September 4, 2024

**RE: Event Center
1611 Airtech CT. SE
Erosion and Sediment Control Plan
File: N15D017**

This letter is a response to the comments dated August 20, 2024, and is being provided with resubmitted SWPP documents. Please refer to the response under each comment.

**GRADING PLAN**

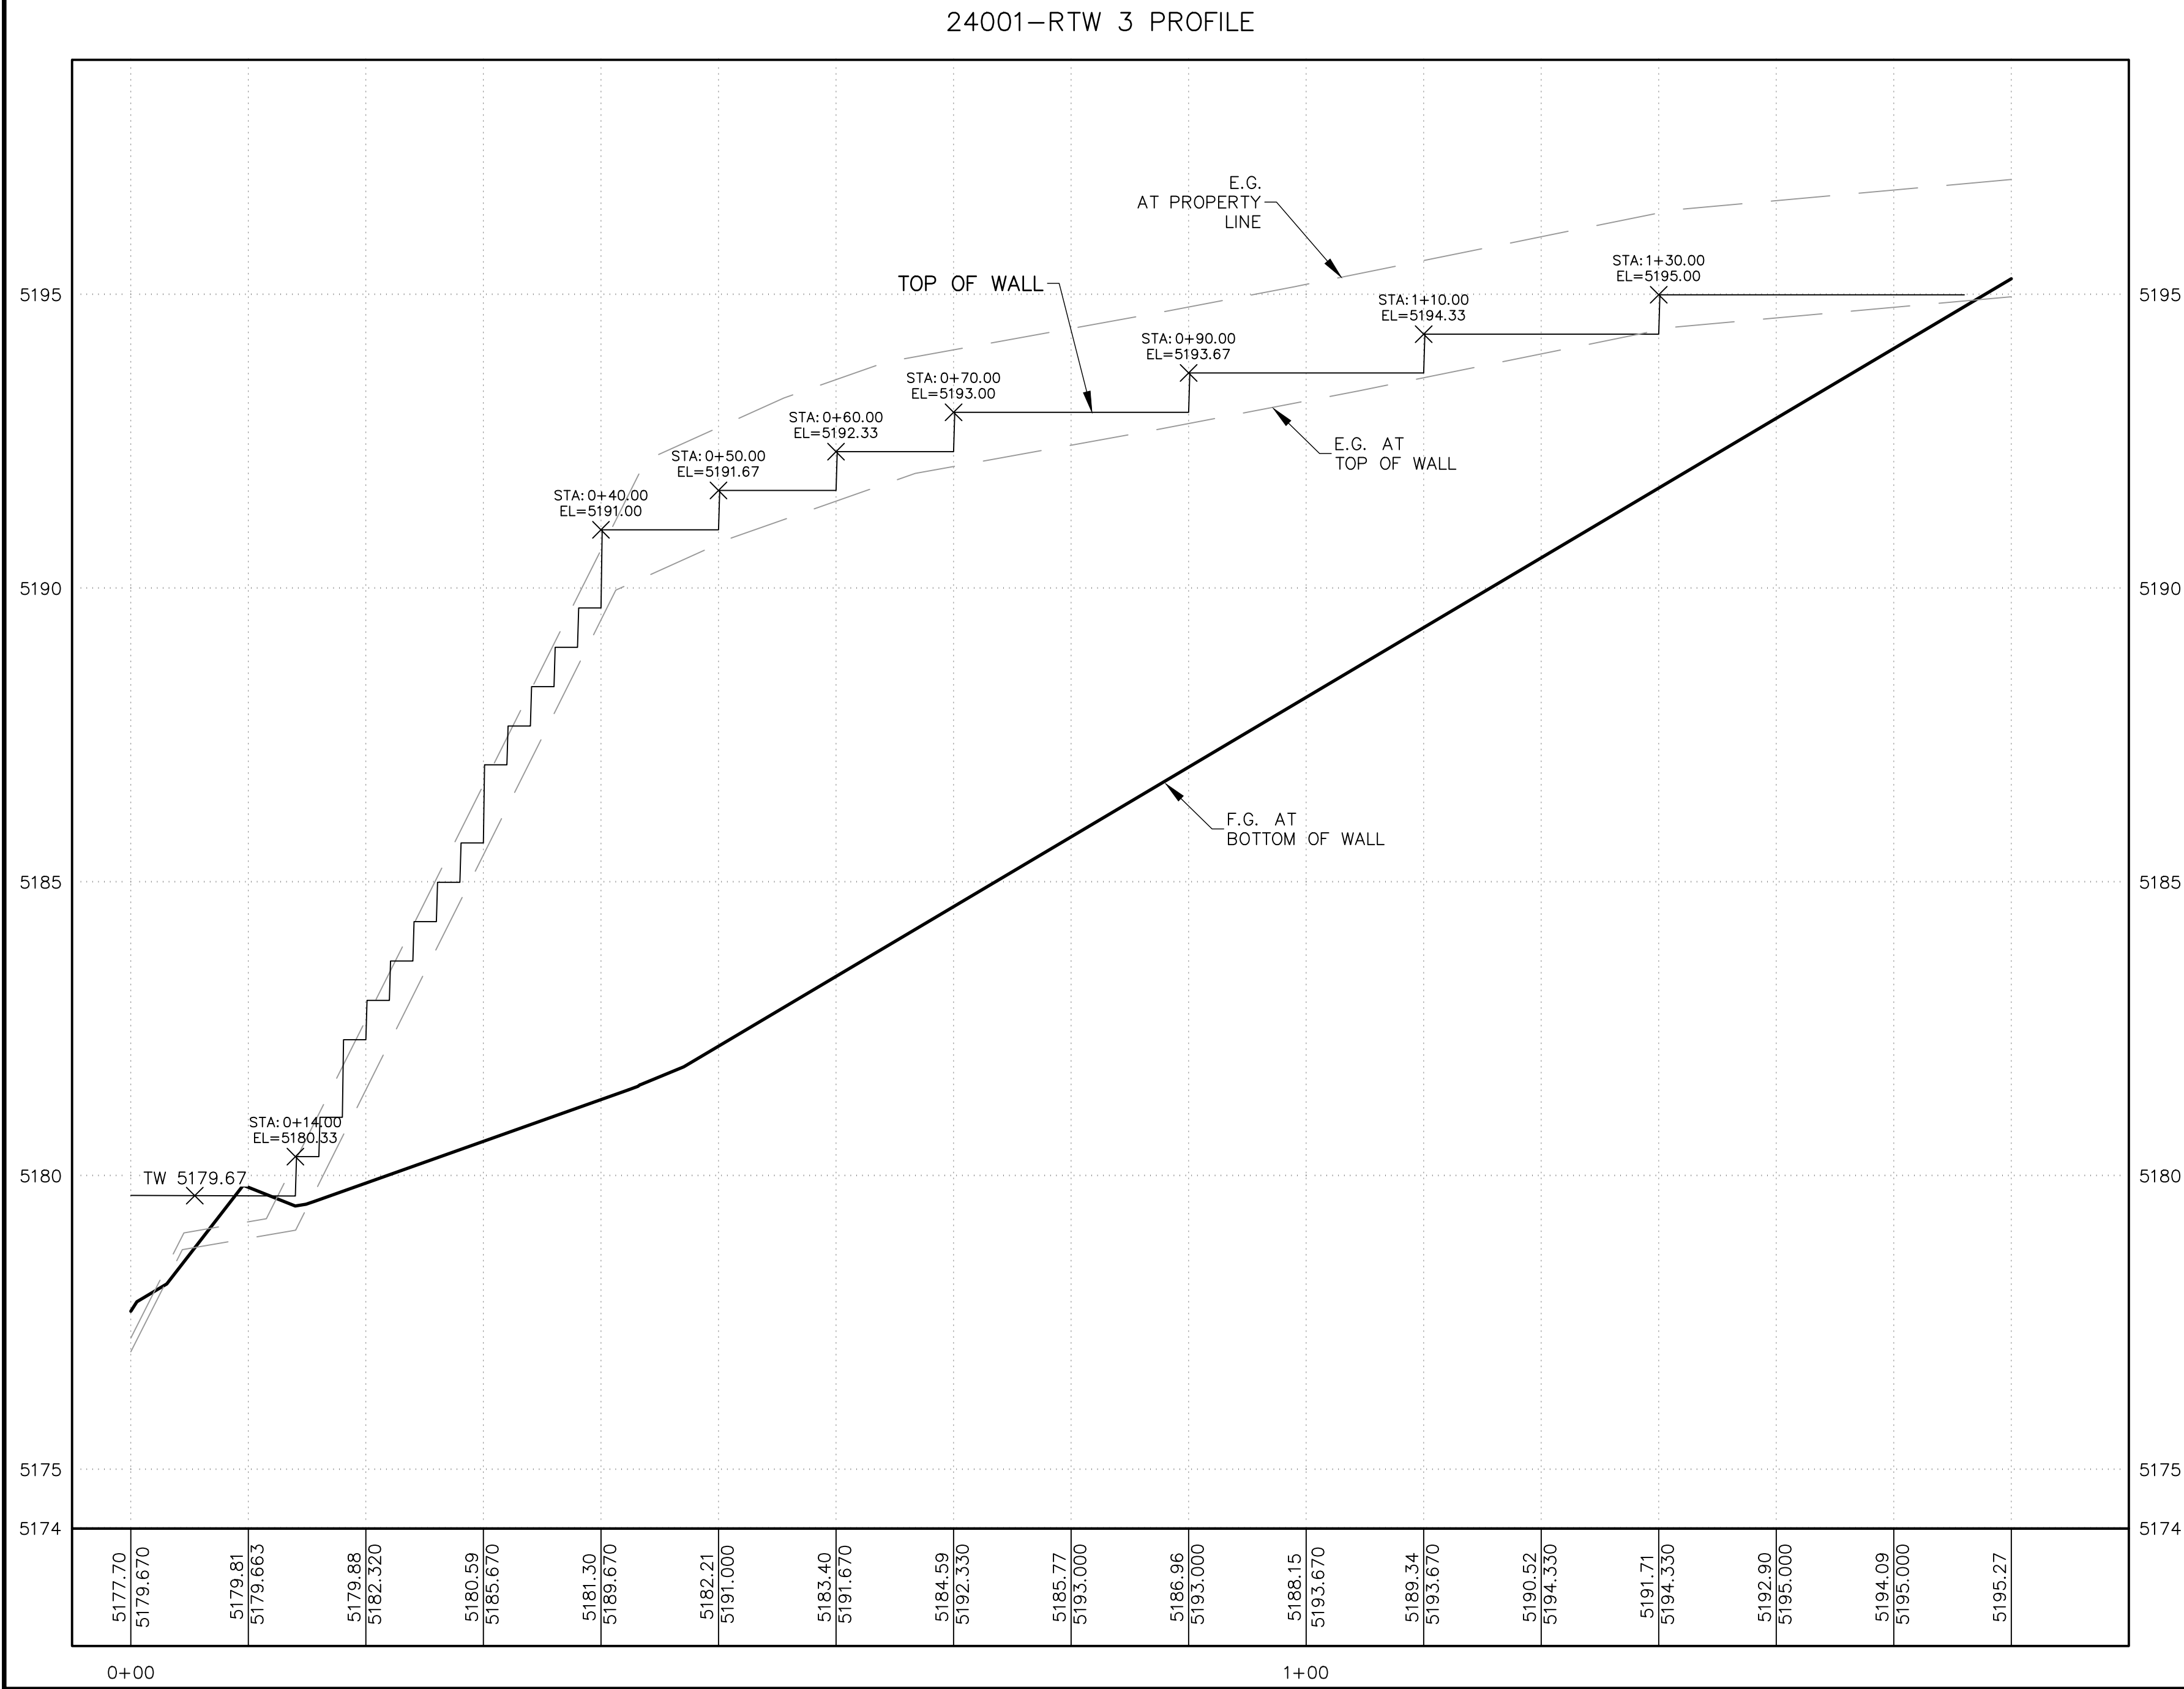
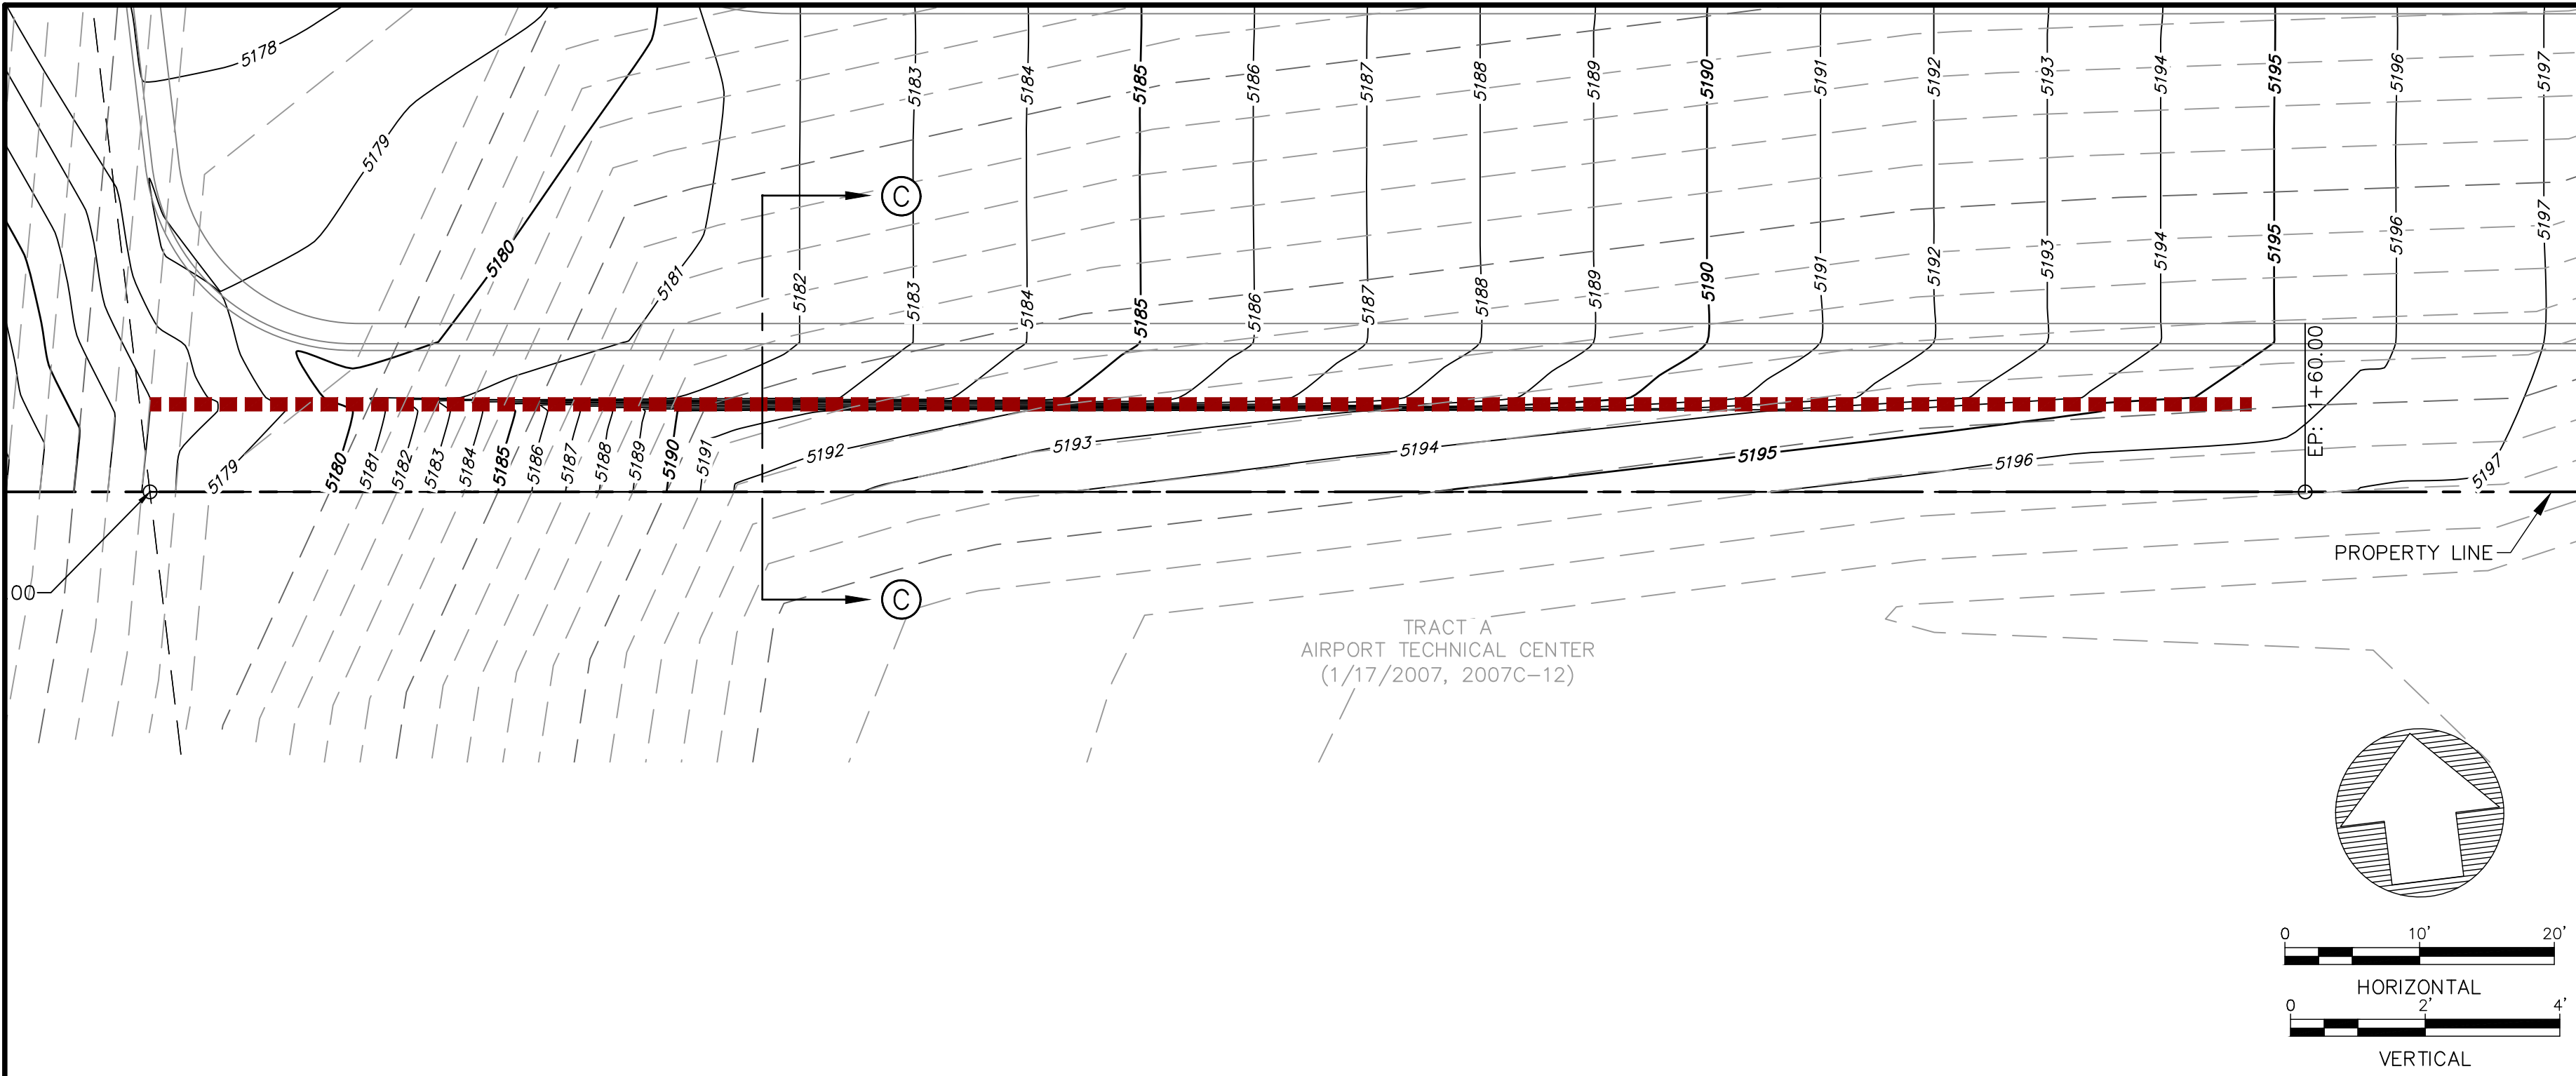
The ESC Plan can't be approved until after Hydrology approves the G&D Plan for each specific purpose, Site Plan, Grading, Building Permit, and Work Order. Hydrology has not approved the G&D Plan for any purpose so far. The existing and proposed grades must be shown on the ESC Plan and agree with the Grading Plan approved by Hydrology per CGP7.2.4.b.ii.

- **Response:** Shahab Biazar, City Engineer, approved rough grading based on Grading Plan sealed 6/20/2024. See attached email thread. Existing and proposed contours agree.

SHEET TITLE  
RETAINING WALL  
No. 3  
PLAN & PROFILE

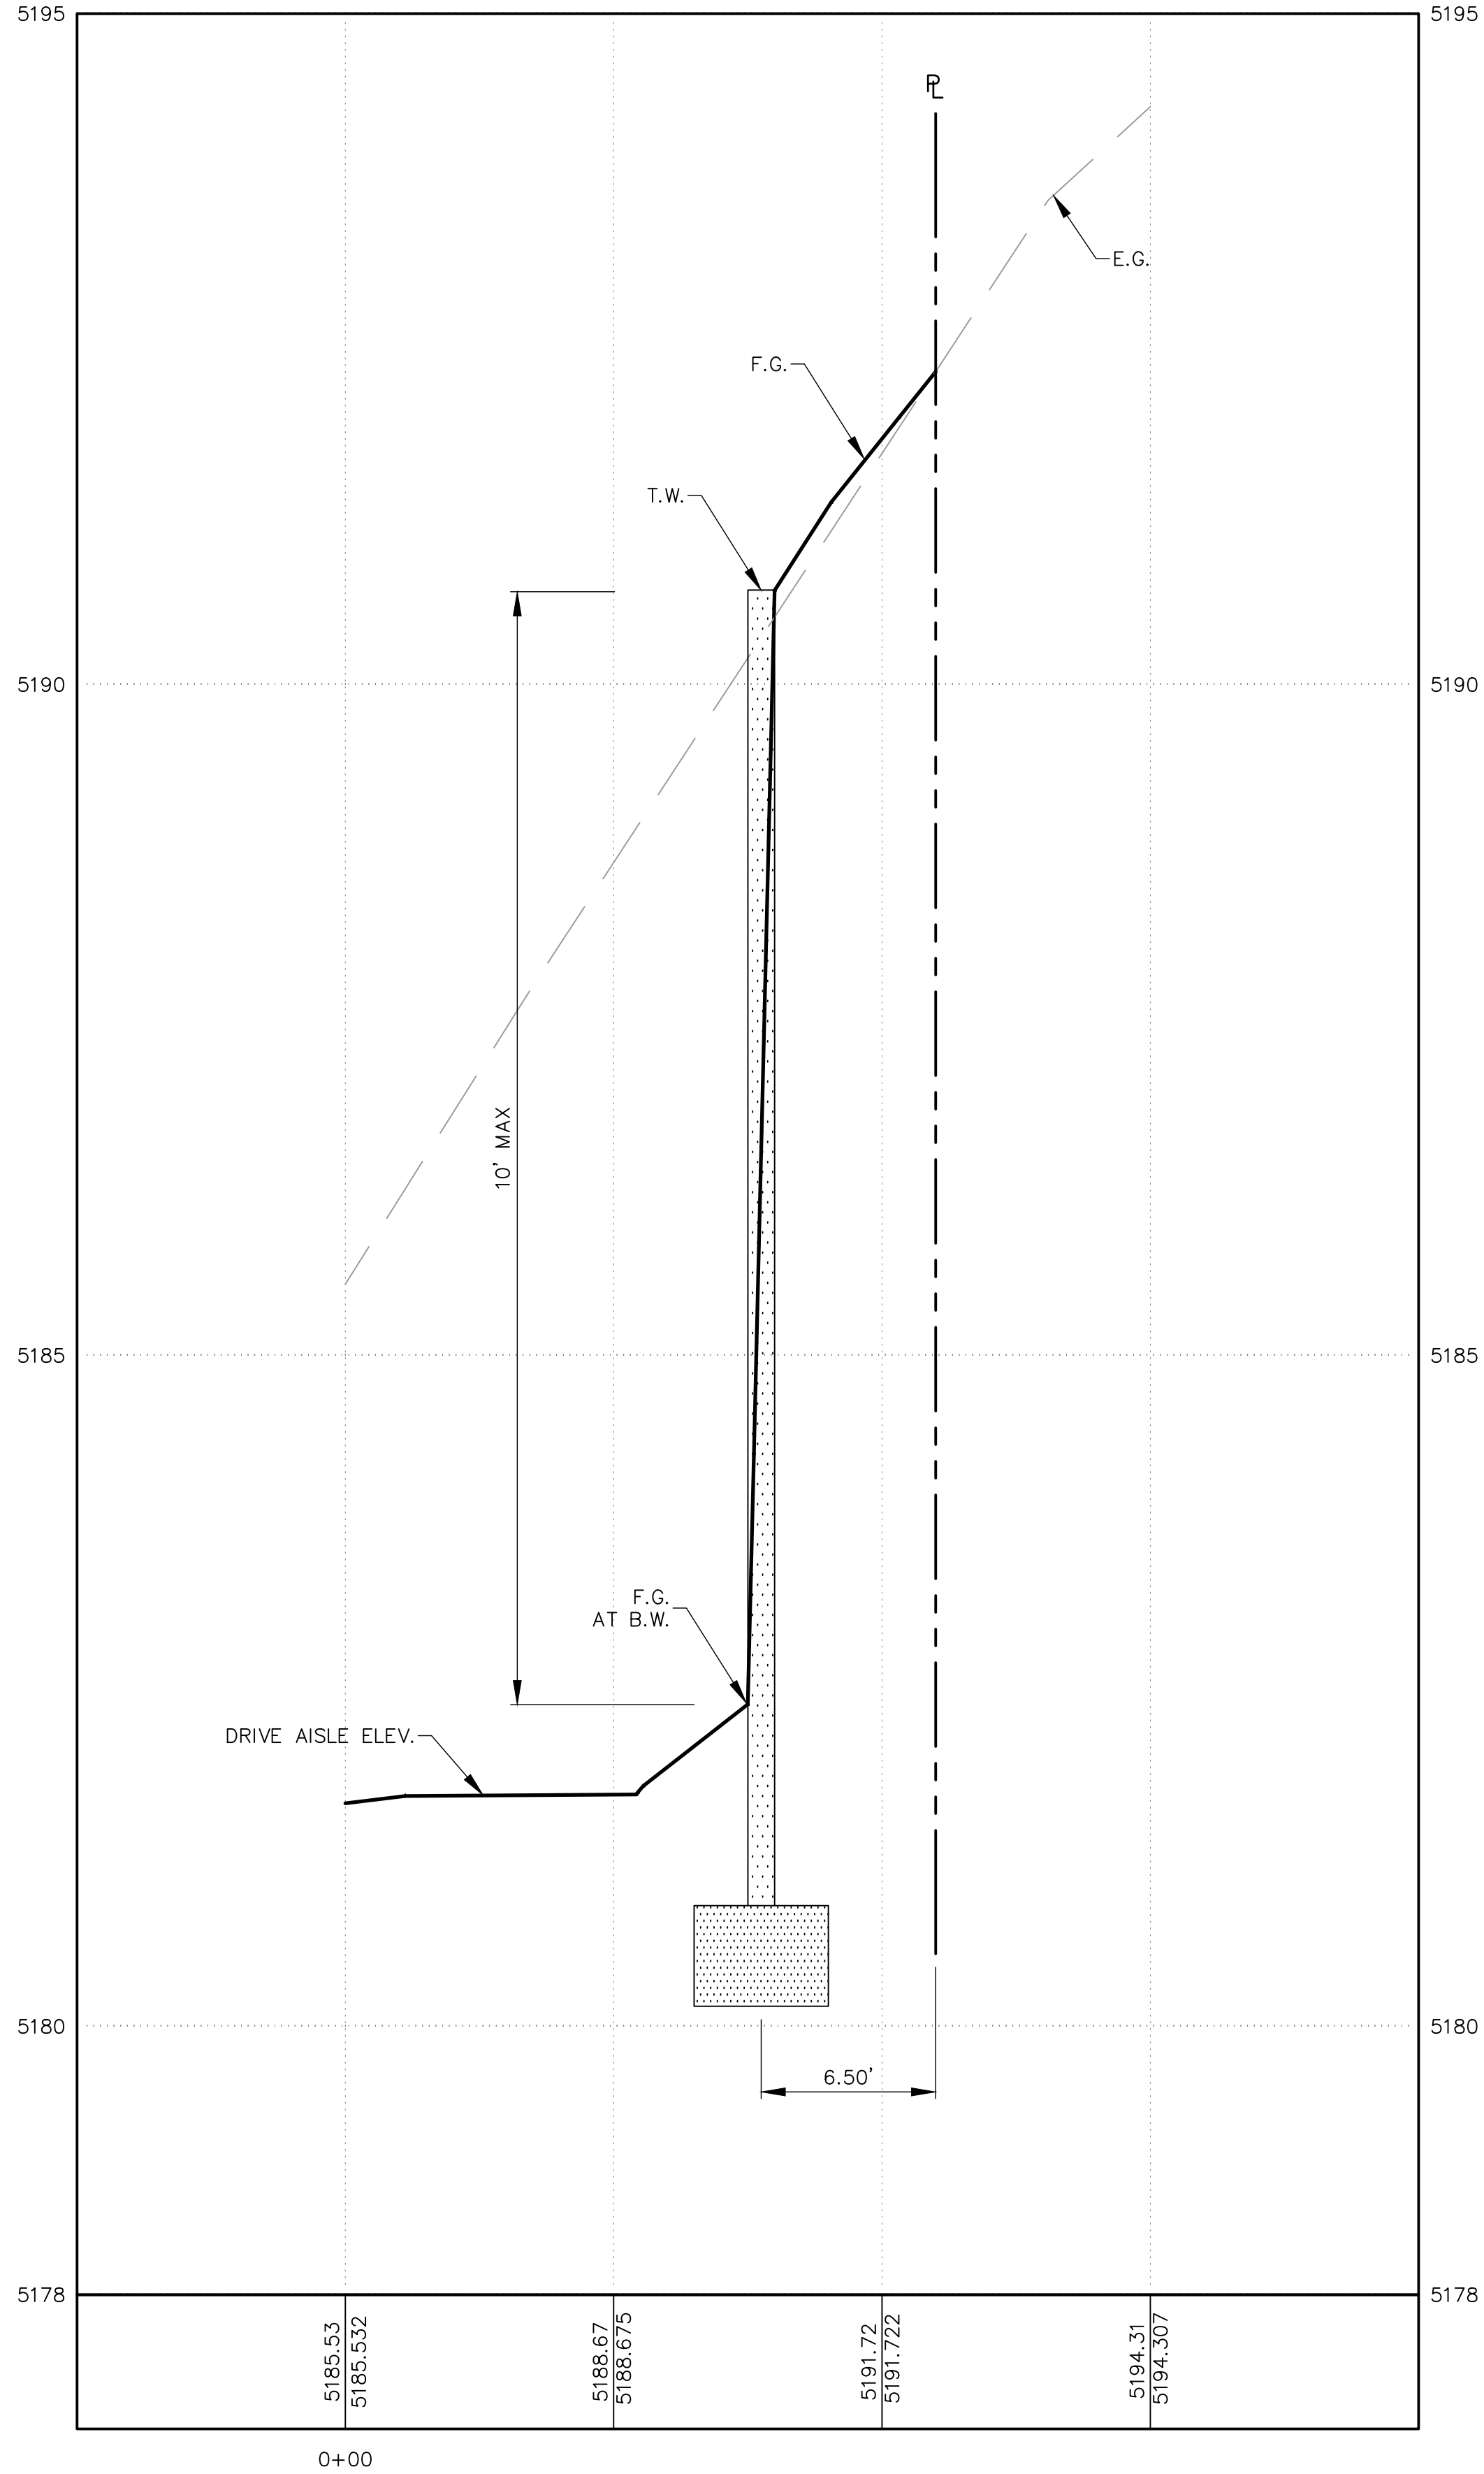
Identify areas of construction support activities on adjacent lots per CGP 7.2.4.b.vii, if any.

- **Response:** Construction support activity from the north adjoining property is required to build the retaining walls along the north property line. Retaining wall PNPs are included and are for information only. This plan along with the ECP show the limits of construction support within the adjoining lot.
